19 June 2013

**Re: MP07_0070 Wollongong Private Hospital
Section 75W Modification Application
Heritage Impacts**

TRUE NORTH ↑	Drawn	Checked	Date	Scale
	CQ	HMC	03.06.13	1:500 @ A3
PROJECT NORTH ⊕	Drawing Title BUILDING EXTENT COMPARISON ELEVATIONS

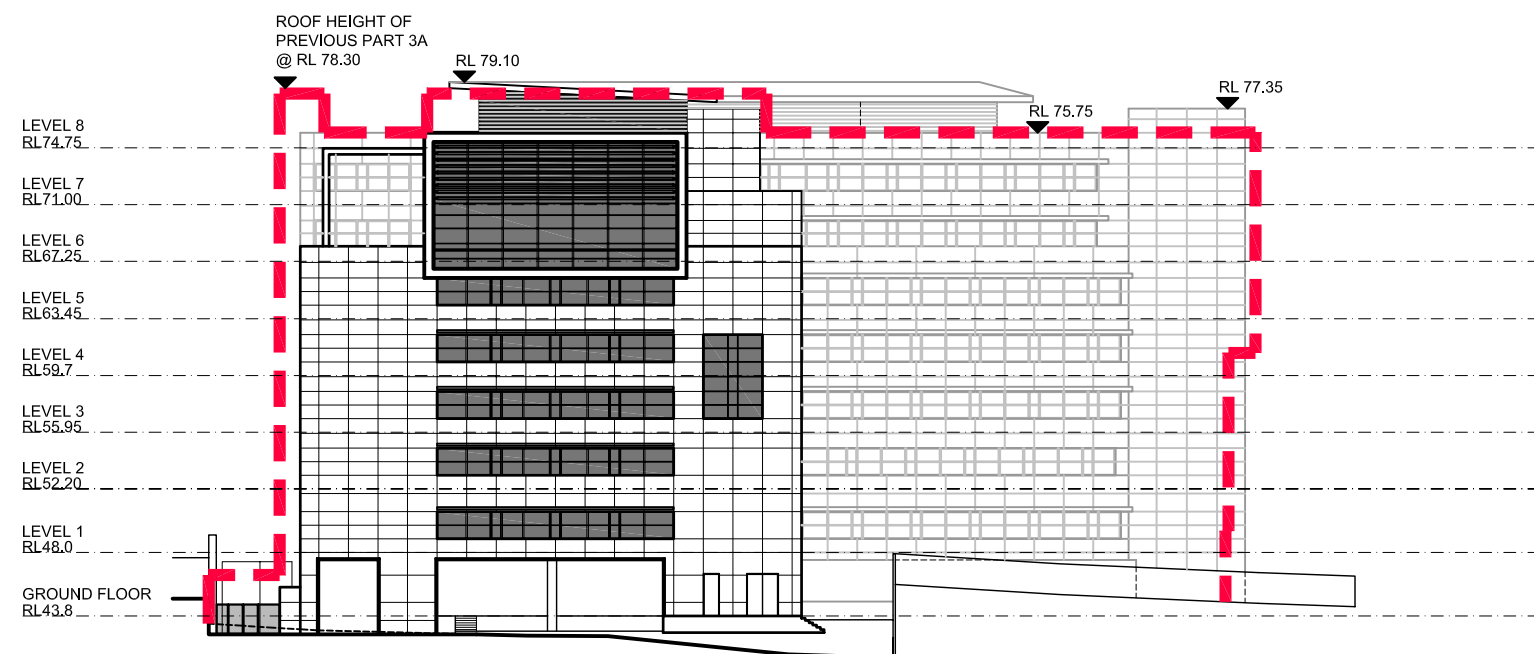
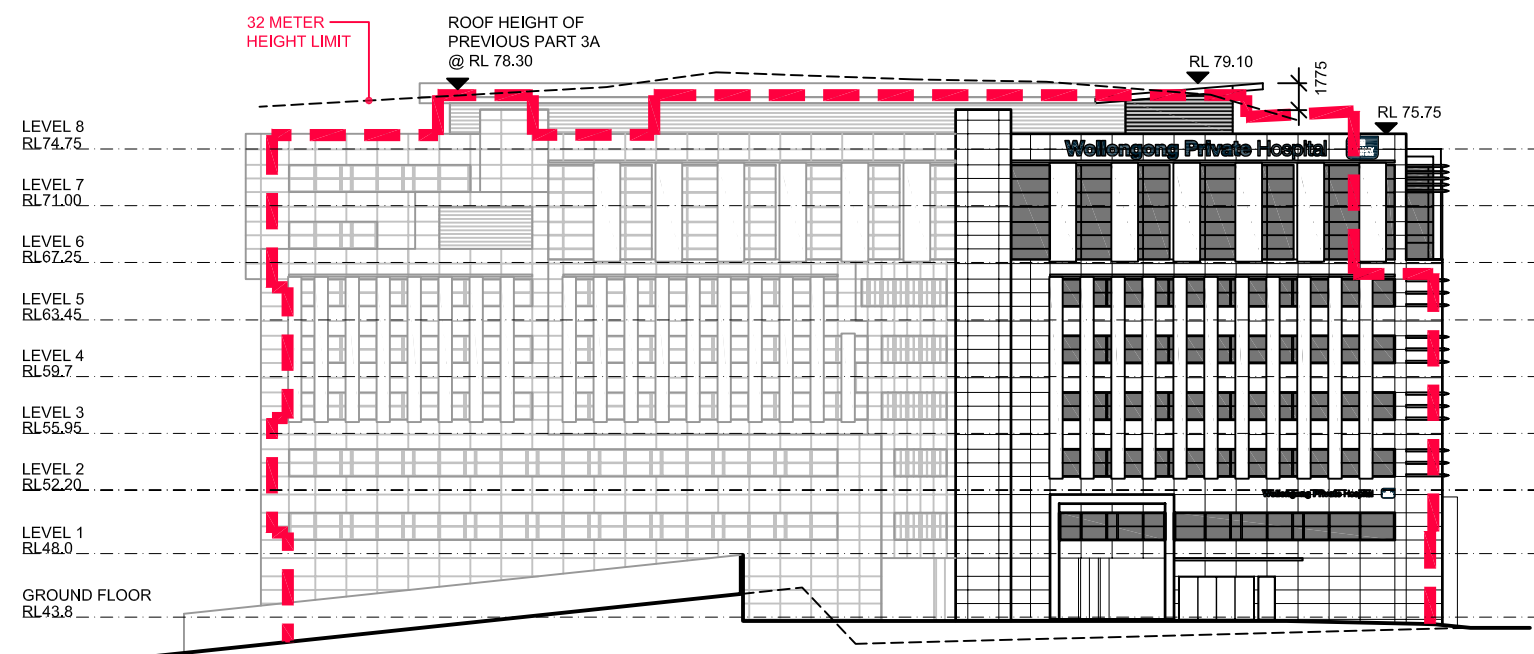
The building as now proposed does not step down towards the heritage item and the statement that parts of lost views to and from the verandah of the heritage item would be recovered no longer holds true. The modification can then be seen to have a greater (though still minor) adverse heritage impact than the approved scheme. Views from the verandah are retained by the southwest corner setback to some degree.

In assessing the heritage impact upon the item at 366 Crown Street, the relatively low level of significance of this former house should be borne in mind. Although the modified proposal does not accommodate the retention and recovery of views to and from the adjacent heritage item to the same degree as the approved project, the impacts on the setting of what is quite a modest heritage item remain acceptable.
